24 April 2019

Submission made by Highways England pursuant to Deadline 3 of the Examination of the A30 Chiverton to Carland Cross scheme

Appendix A: Overview of changes made to plans

Drawing Title: **LAND PLANS
 APFP REGULATION 5(2)(1)
 SHEET 6 OF 10**

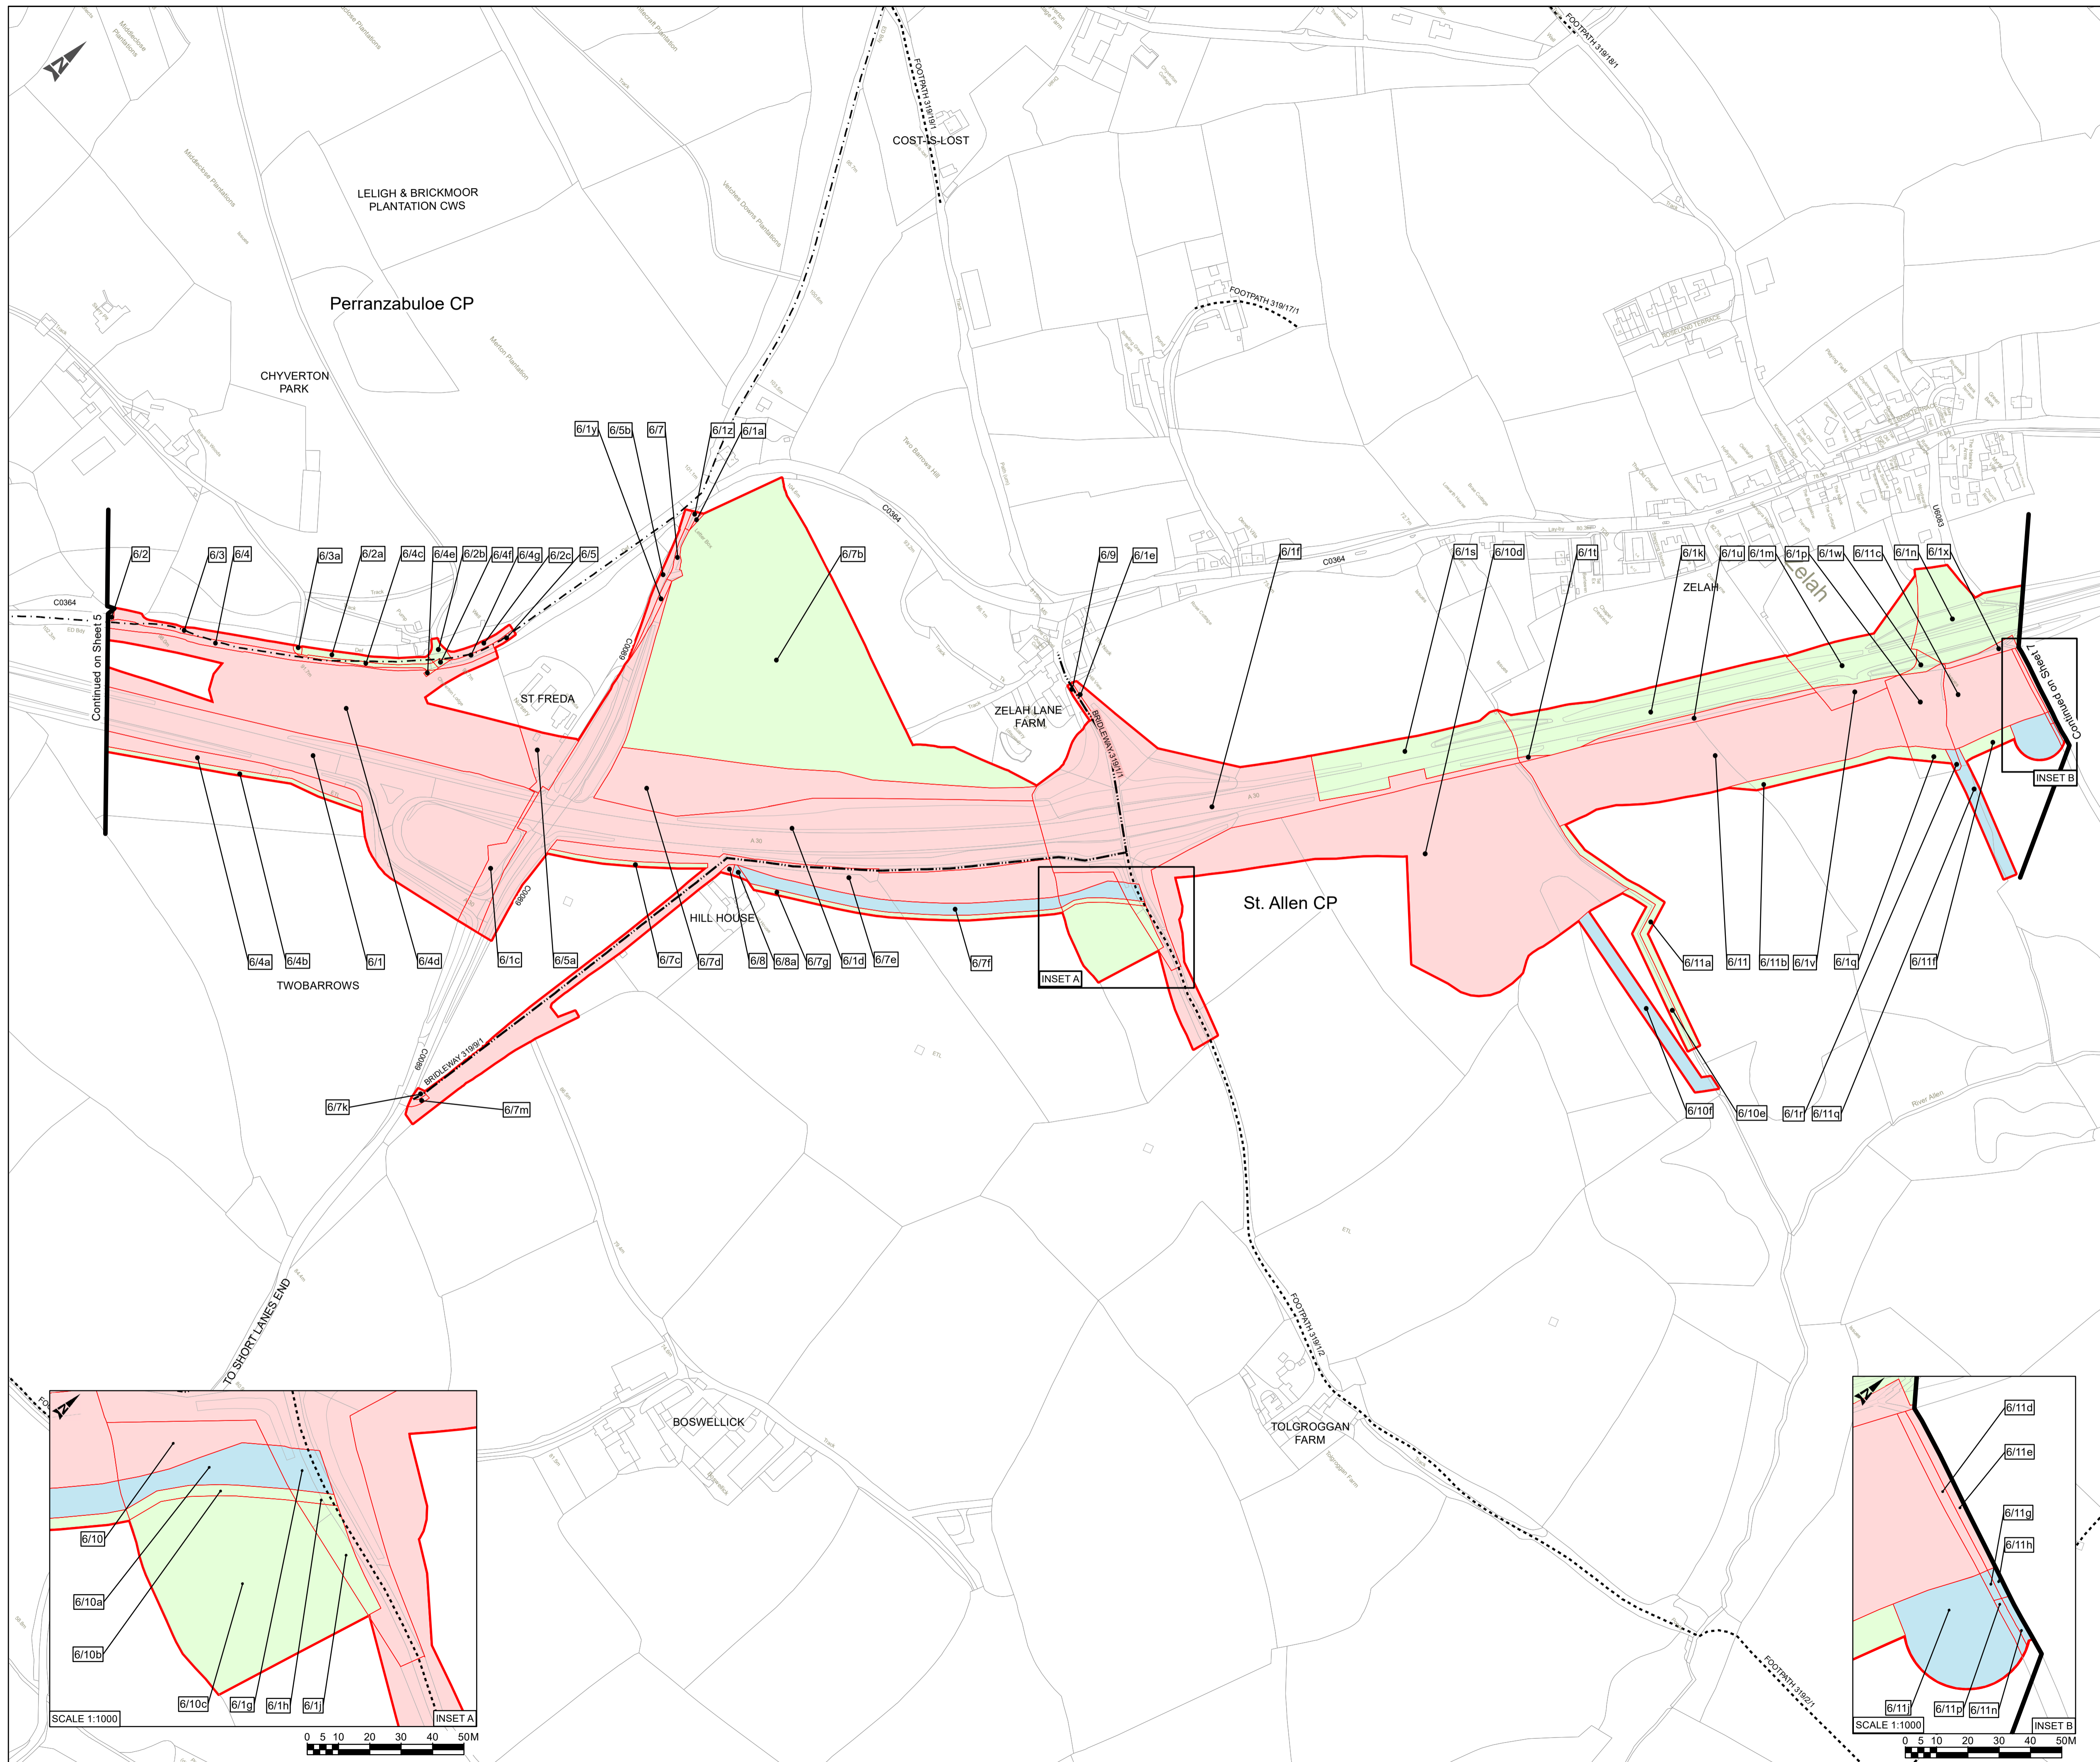
Sheet 6	Reference 28 added Private Means of Access to field east of Pennycomequick.

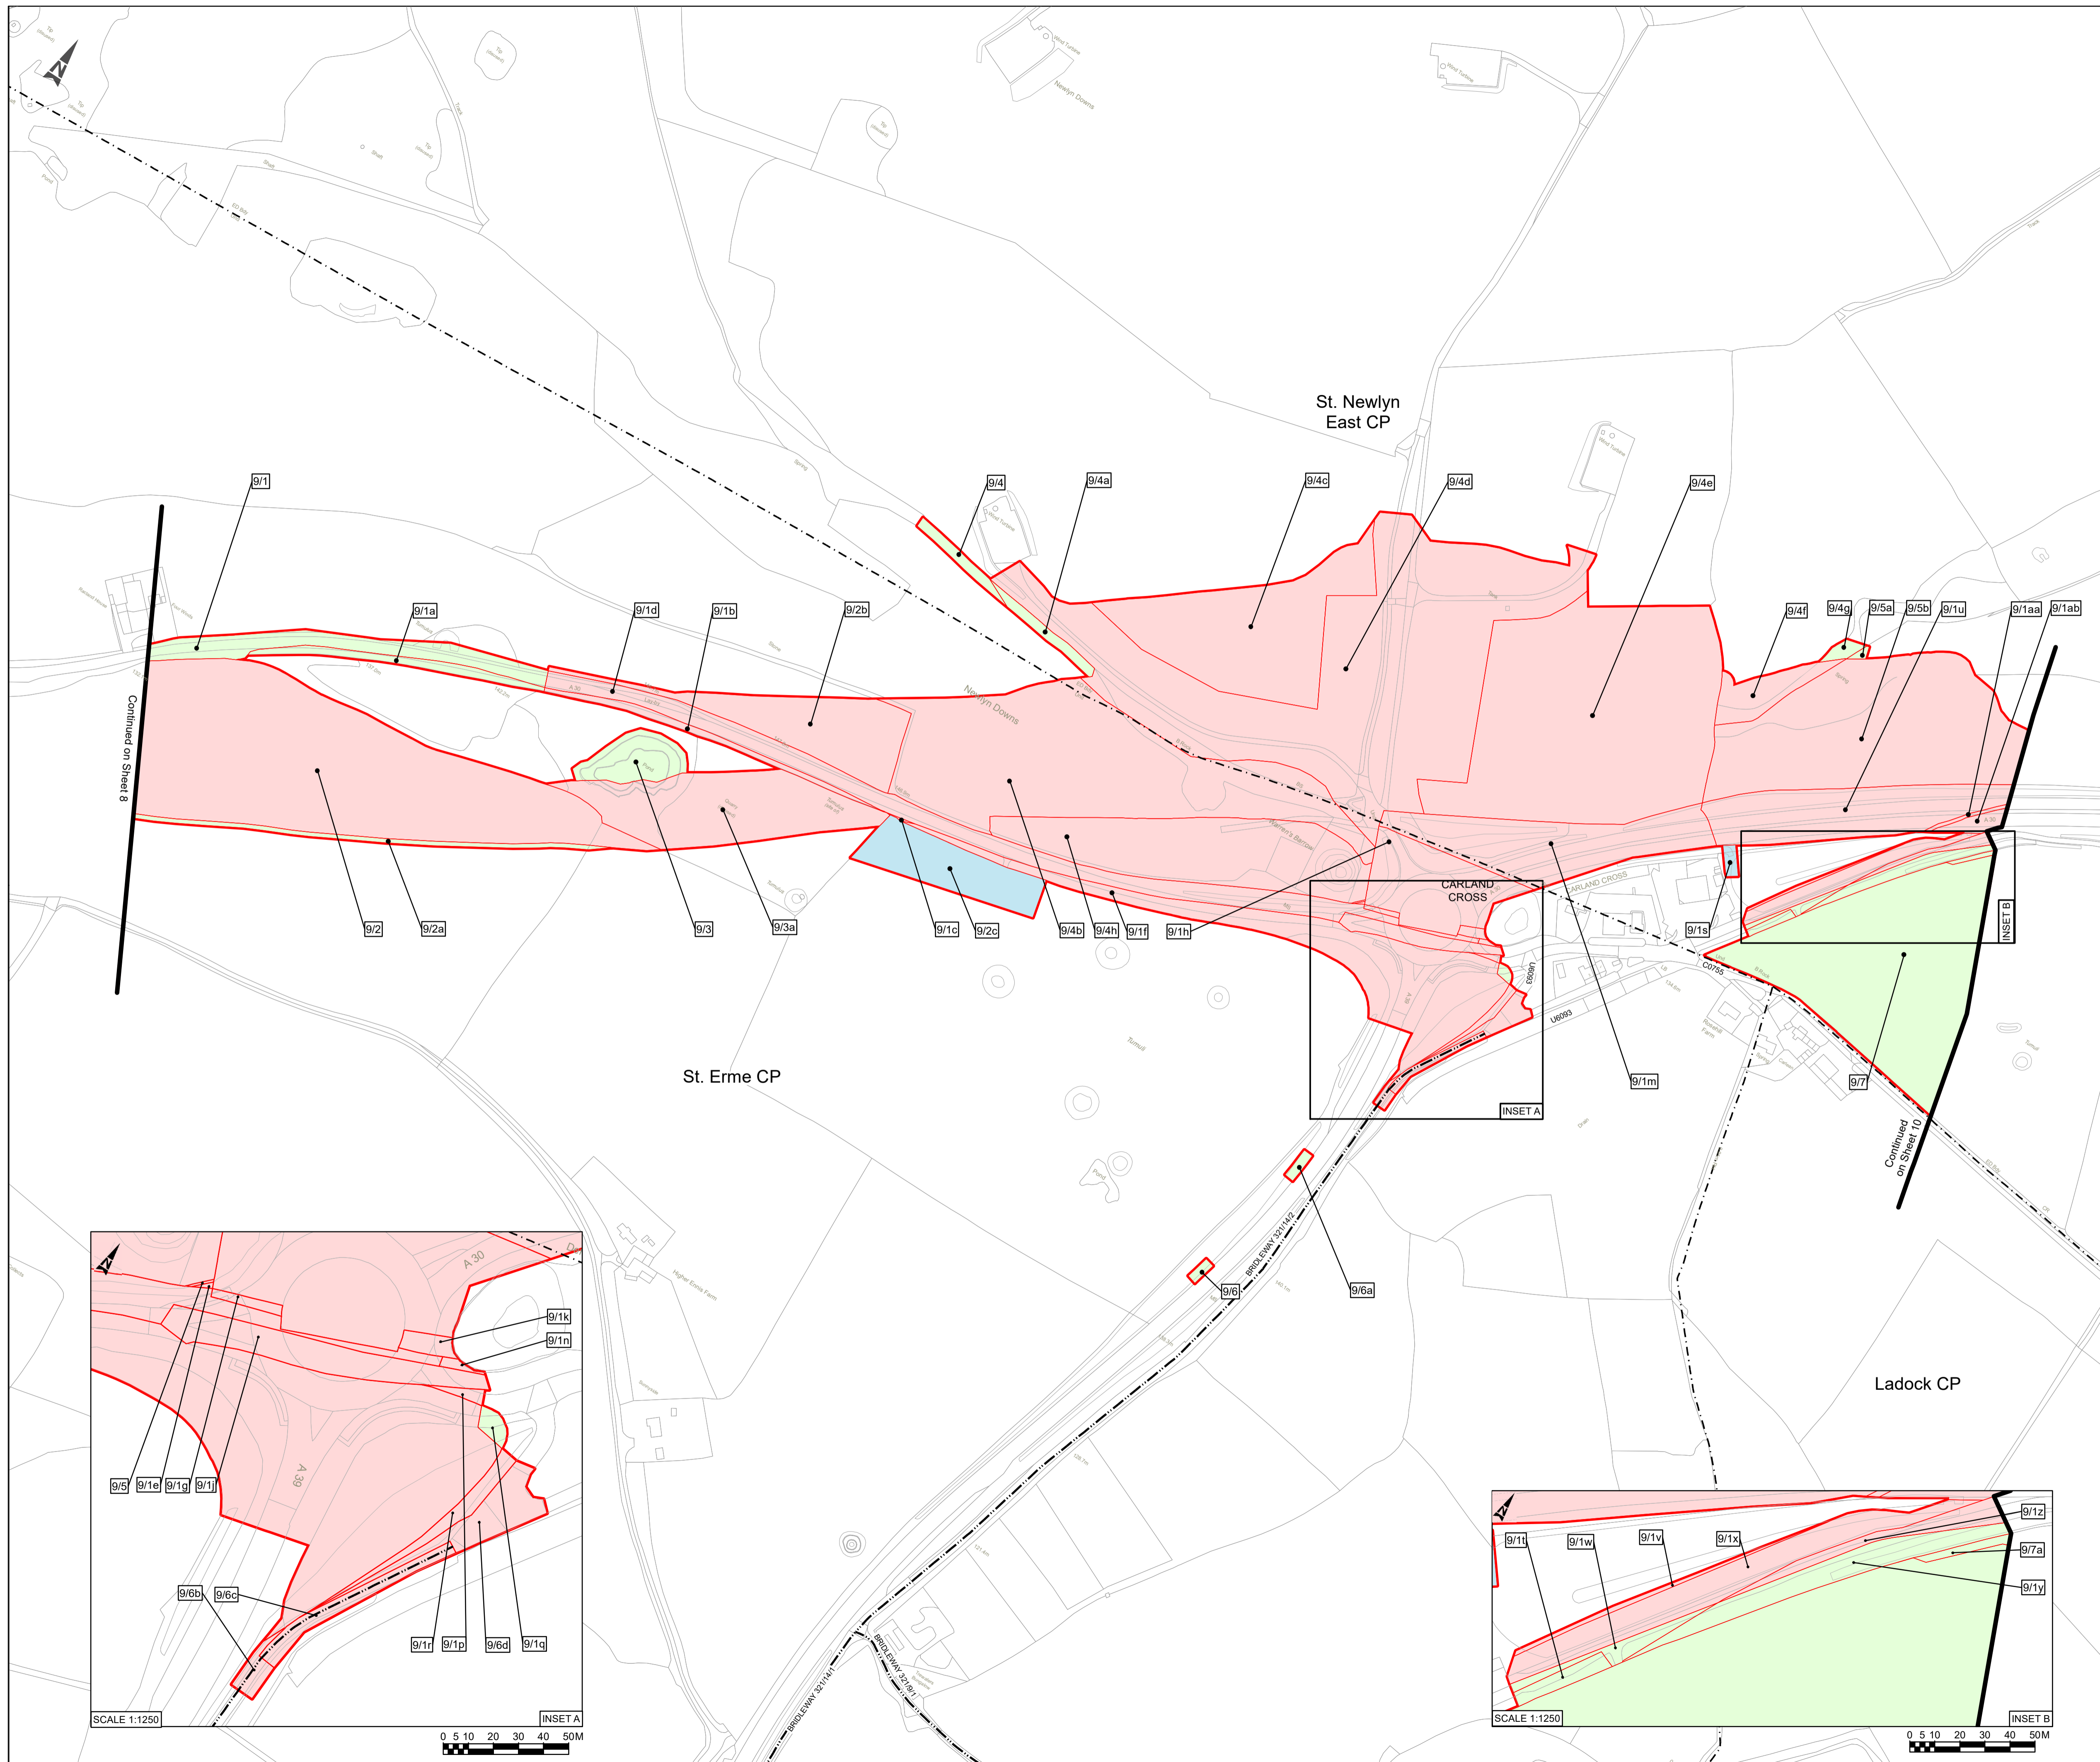
Relevant Plan	Explanation of change(s) made
Land Plans (Document Reference 2.2(B))	
Sheet 5	New plot 5/2m
Sheet 8	Pennycomequick- change of land acquisition from permanent to temporary and temporary with permanent rights. Plots affected, 8/2c, 8/2d, 8/2e, 8/2f, 8/2g (removed). New plots 8/2h, 8/2j, 8/2k
Works Plans (Document Reference 2.4(C))	
Sheets 1 - 8	Updated highway alignment added.
